DEVELOPMENT REVIEW BOARD – SPEED MEMO

DRB CASE NO/PROJECT NO: 1002120

Sketch Plat

RE: Lot 2, Block 10, Monkbridge Place/sketch

418
CHEREKEE ROAD N.W.
70.69'

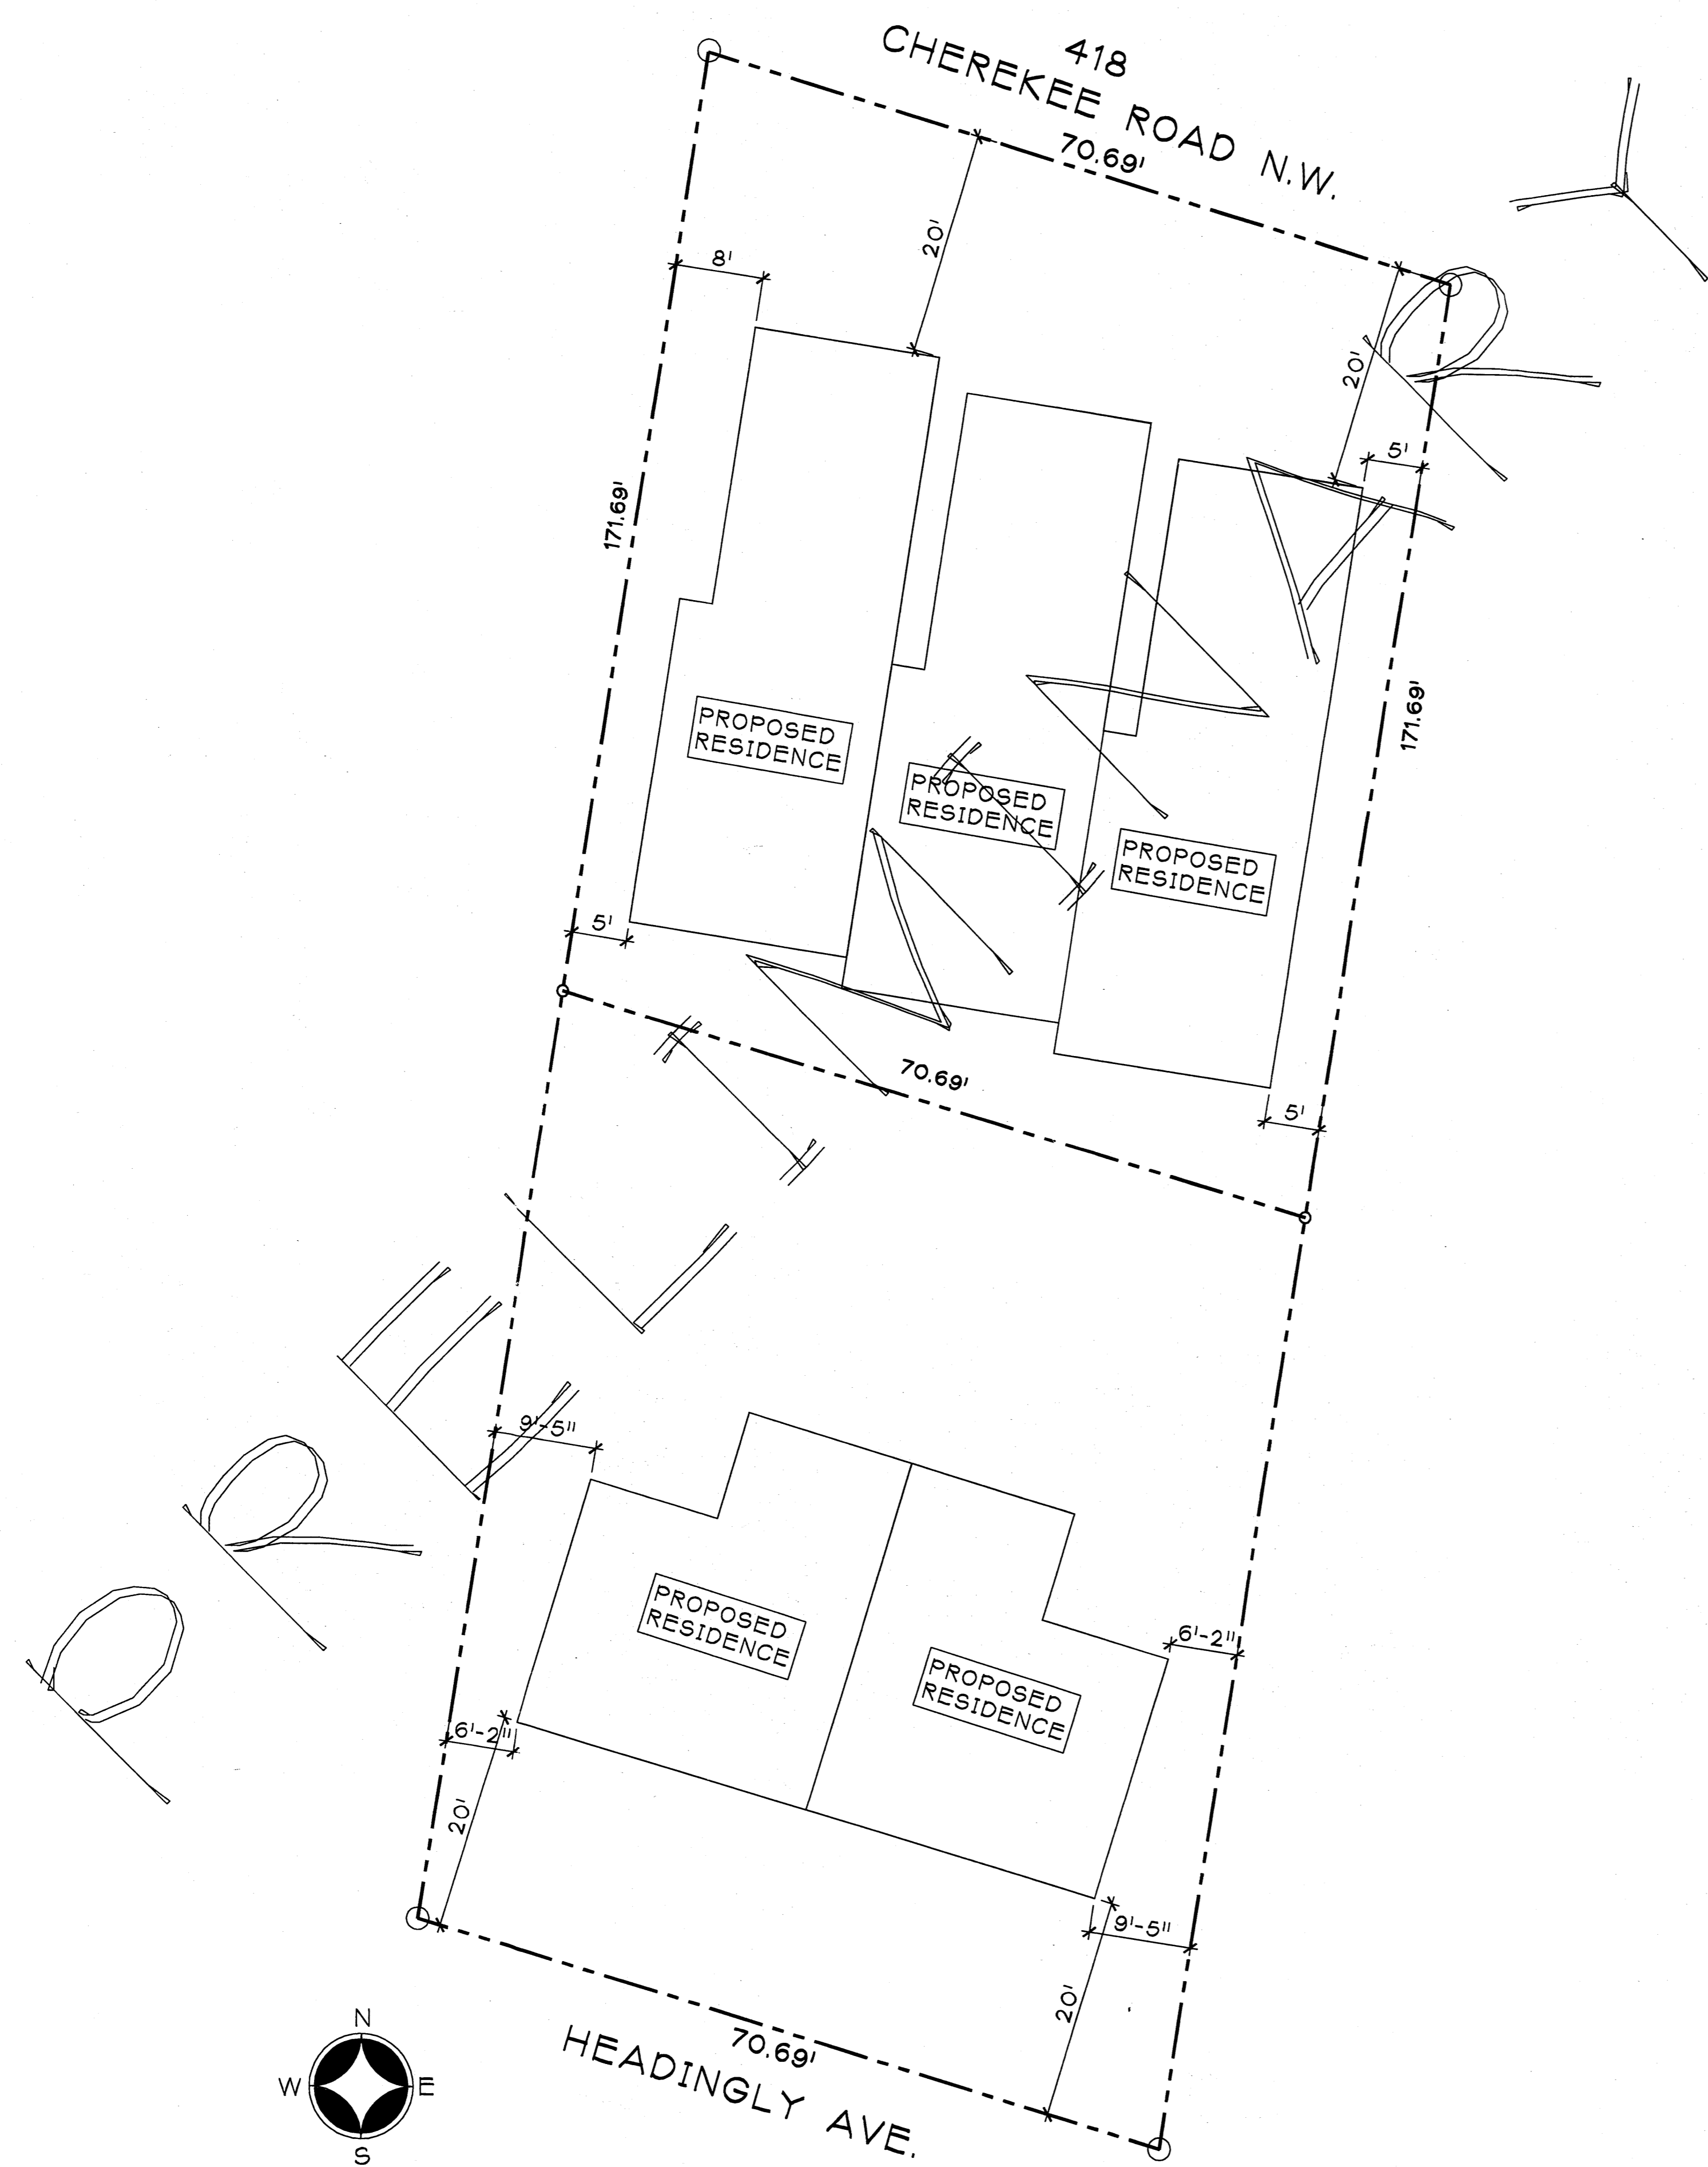
Your application shows that you want to subdivide 1 lot into 5 lots, but your sketch only shows 4 lots, please explain.
